Householder Proforma

Application Ref: 2021/1038
Address: 129 Laithes Lane, Athersley South, Barnsley, S71 3AH
Neighbour Representations: No
Consultations:
Property Description: The semi detached red brick built property is located on Laithes Lane, a main route within the Athersley/Carlton area. The dwelling is located on an access road, set back from the main highway and benefits from a two storey rear extension.
Proposed Extension: Erection of two storey side extension to dwelling
UDP Designation: Housing Policy Area
Local Plan Designation: Urban Fabric
Conservation Area: No
Relevant History: 2014/0684 – Erection of a two storey rear extension – Approved October 2014
Acceptable in Principle: Yes

Side Extension:

TITLE
PROPOSED EXTENSION
GENERAL ARRANGEMENT

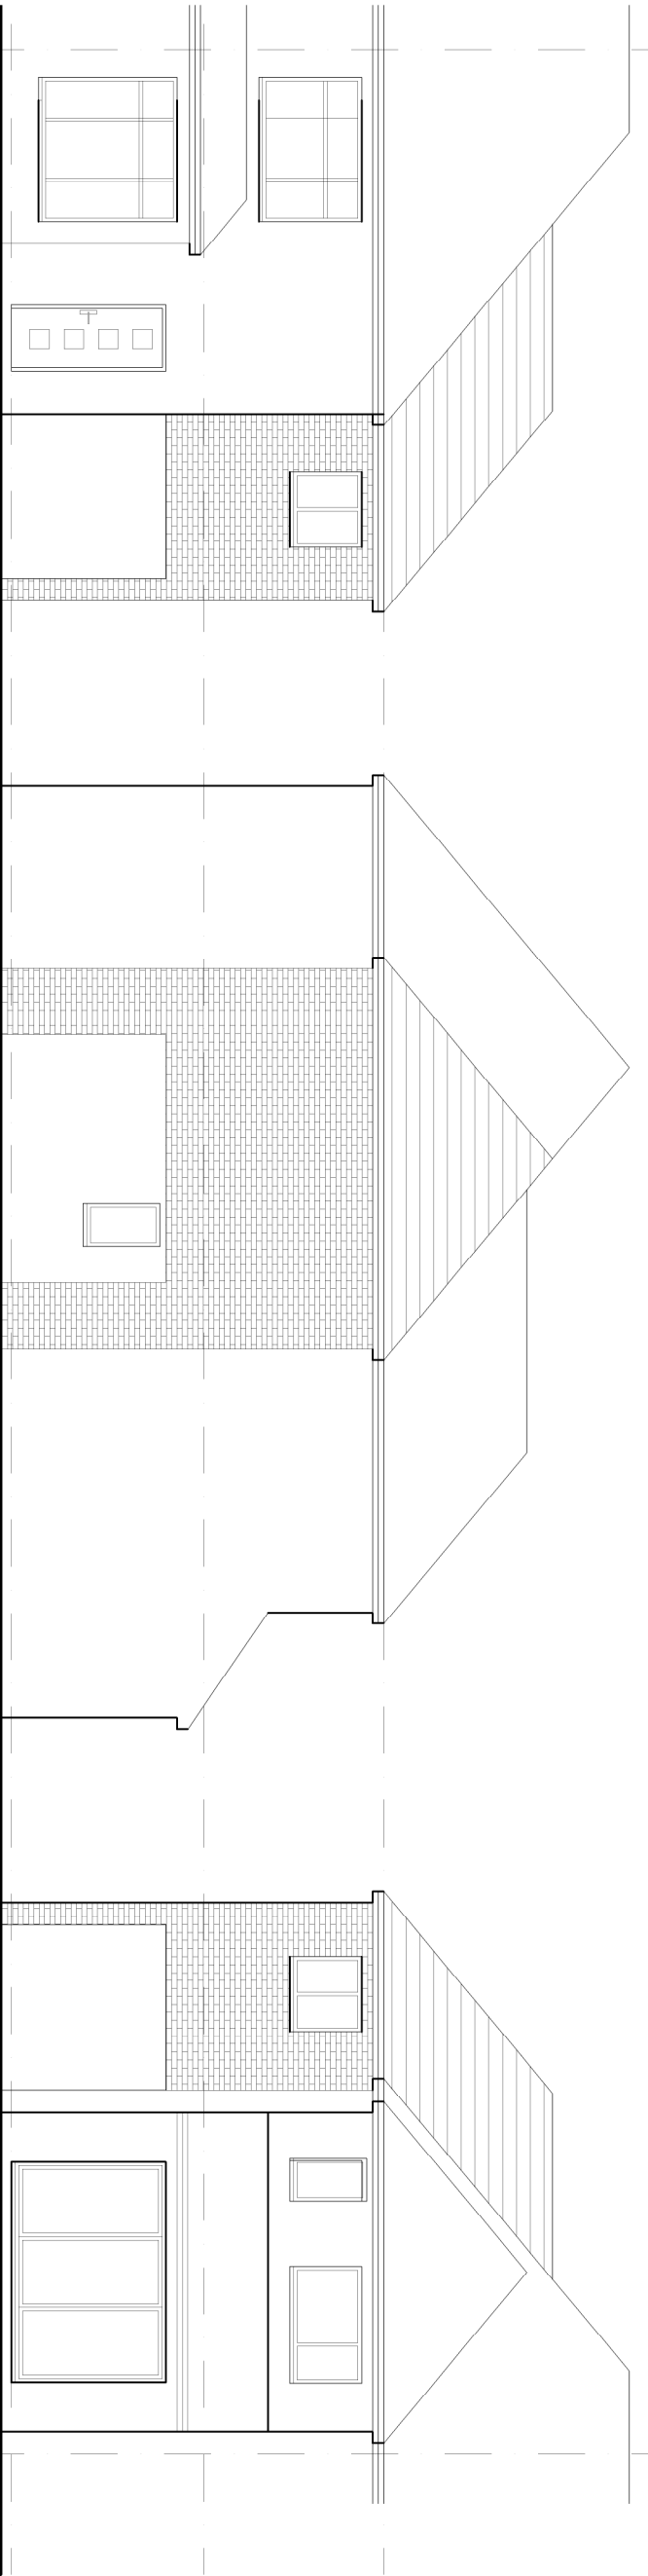
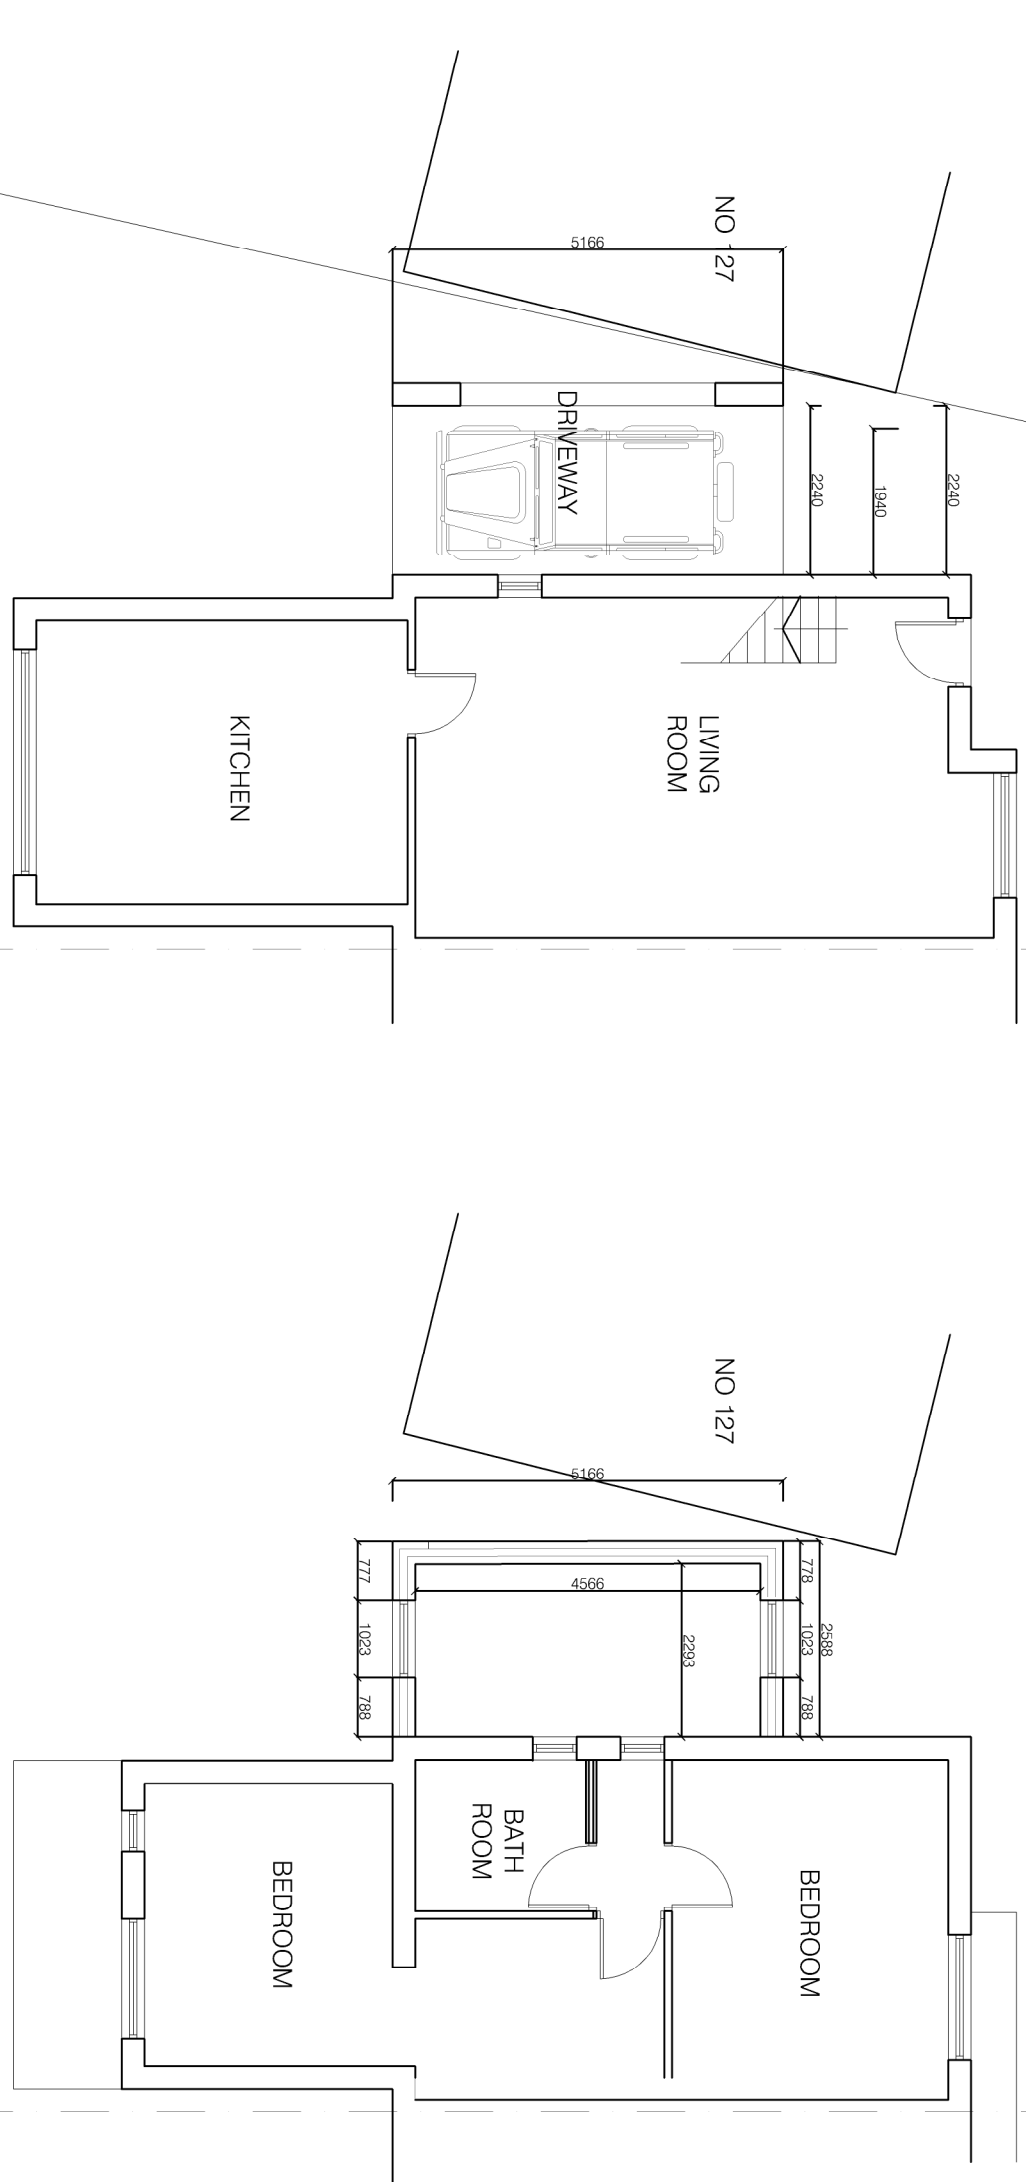
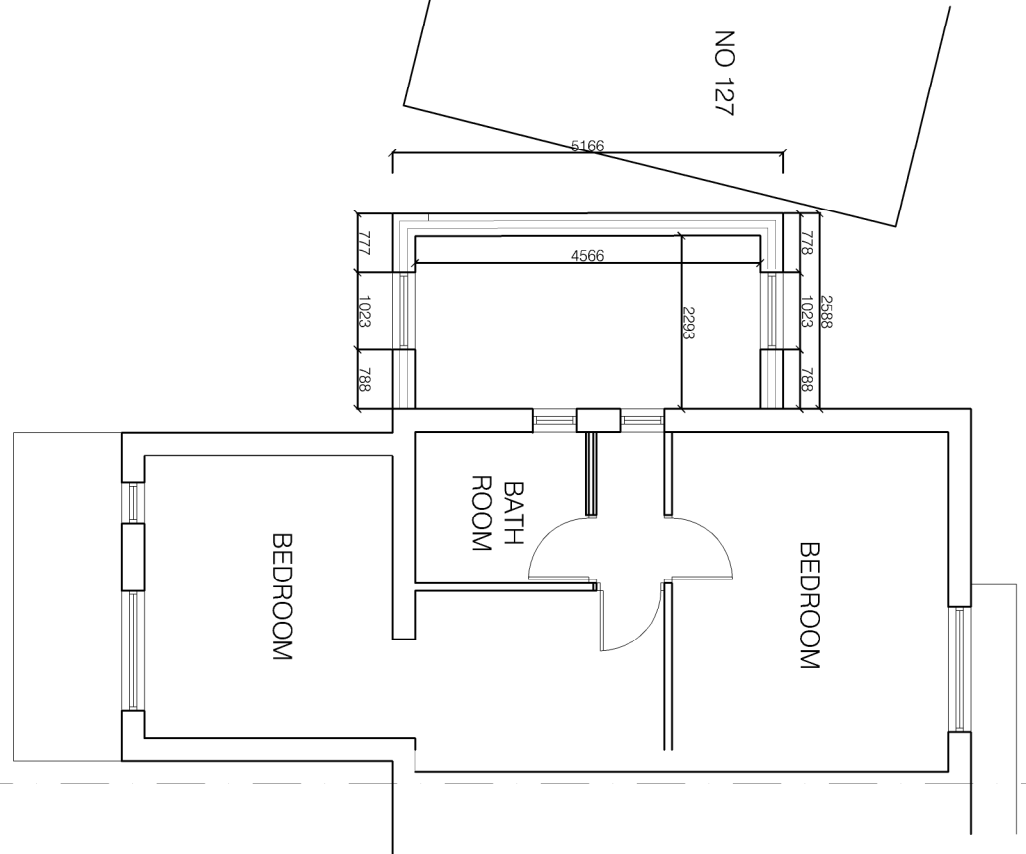
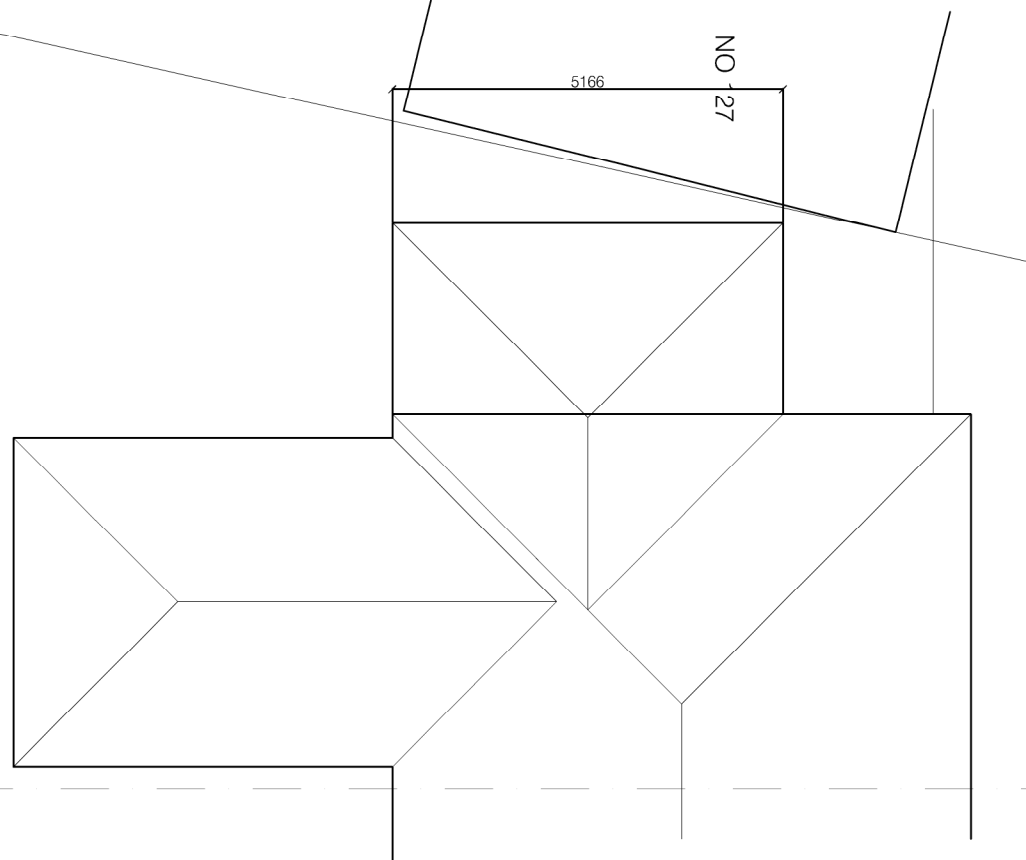
Yes / No (include comment if required)
Single Storey	
1. set back	
Two Storey / First Floor	
2. set back / set down (500mm minimum)	Yes; 2.5m
3. less than 2/3 the width of the original dwelling	3.2 allowed 2.6m proposed

All	
4. roof design corresponds to existing	Yes
5. windows / doors of a similar design / proportion	Yes
6. habitable room windows on the side elevation	No
7. materials to match	Yes
8. neighbouring property extended to side or windows?	
9. Any change to parking or access?	Undercroft parking proposed sufficient size for vehicle with sufficient driveway length for additional vehicle

Recommendation: Approve with conditions
